# Longfield Solar Farm

Statement of Common Ground – National Highways

Document Reference: EN010118/EX/8.4(C)

November 2022

Appendix B – Surrounding Highway Network

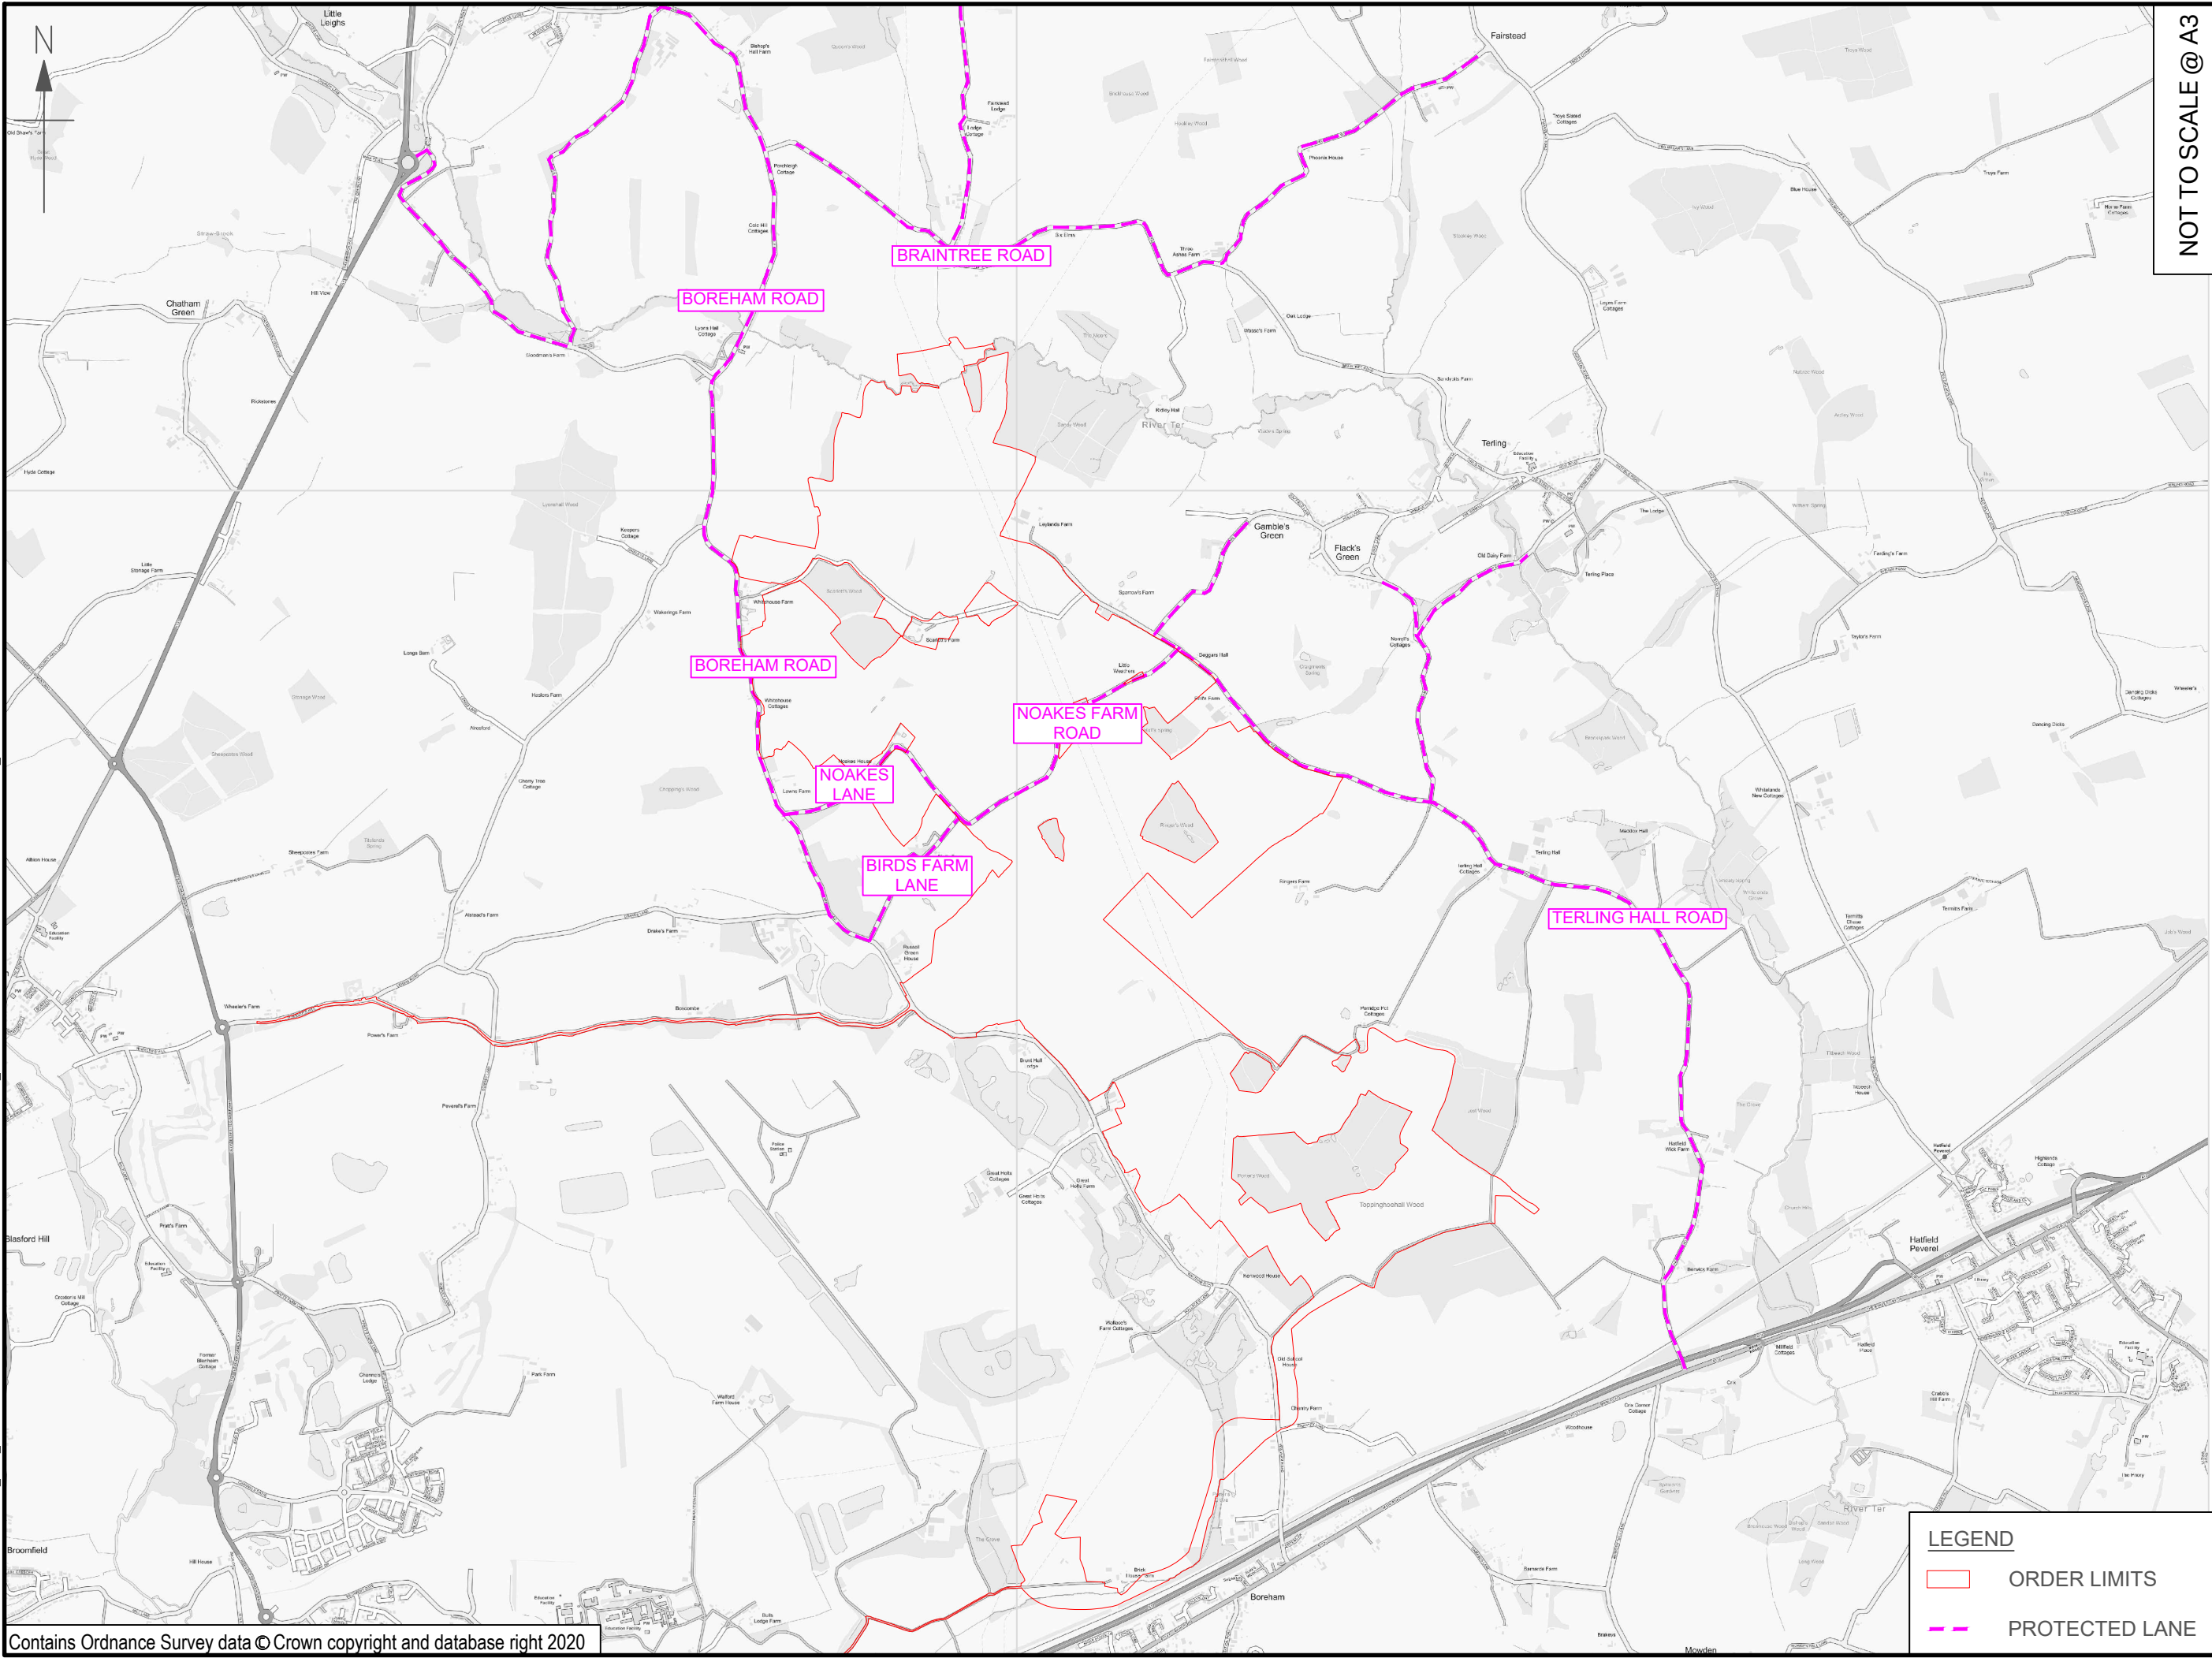
4.9	Private Road to/ from Bulls Lodge Substation	As mentioned in the Framework CTMP and shown in 'Appendix B – Surrounding Highway Network', Longfield Solar Farm proposes to utilise a private road via Boreham Interchange/RDR for Bulls Lodge Substation compound and construction. The A12 Scheme also proposes to utilise this private road's access for construction purposes including a haul route, compound and lay down area and soil storage. Effort is being made between both parties to ensure the private road is shared between both schemes during construction, working together to agree and establish this in the SoCG. However, there remains uncertainty with regards to the status of the private road. The private road is currently owned by Countryside Zest (Beaulieu Park) LLP and is expected to become an adopted highway upon completion of the Beaulieu Park development, the timing of which is unknown. Prior to the adoption of the highway, it is still to be agreed which entity will act the Principal Contractor, therefore highway rules to be complied with remain uncertain (i.e. speed limits, access controls). National Highways and	It is acknowledged that there will be a requirement for both schemes to share the private road to/ from Bulls Lodge Substation during construction. Measures to manage construction vehicles along the private road are set out within the Longfield Solar Farm Framework CTMP [EN010118/APP/6.2(A)]. Measures to manage construction vehicles along the private road will also be set out within the A12 Scheme Outline CTMP. Access between the RDR, private road and the A12 will be retained for both schemes, including with respect to the order limits for the proposed haul route, compound and lay down area and soil storage for the A12 to A120 Widening Scheme. Further discussions to be held once the Principal Contractor has been determined.	Agreed

Ref	Sub-topic	Stakeholder Comment	Applicant's Response	Status
		<p>Longfield Solar Farm are working together to agree and establish this in the SoCG. Additionally, National Highways are seeking to ensure access is retained from the RDR/private road to A12 site for construction purposes. National Highways will seek to implement this as a requirement within LSF DCO if necessary. There is a need for agreement to be sought prior the Applicant's DCO decision to ensure appropriate maintenance and liability responsibilities in relation to the impact of the use of the private road for the construction of the Proposed Development and the A12 Scheme are in place prior to any construction programme beginning.</p> <p>[Jacobs on behalf of National Highways Relevant Representation (for the A12 Chelmsford to A120 Widening Scheme), June 2022] [National Highways Written Rep, Paragraphs 7.2 to 7.4, August 2022]</p>
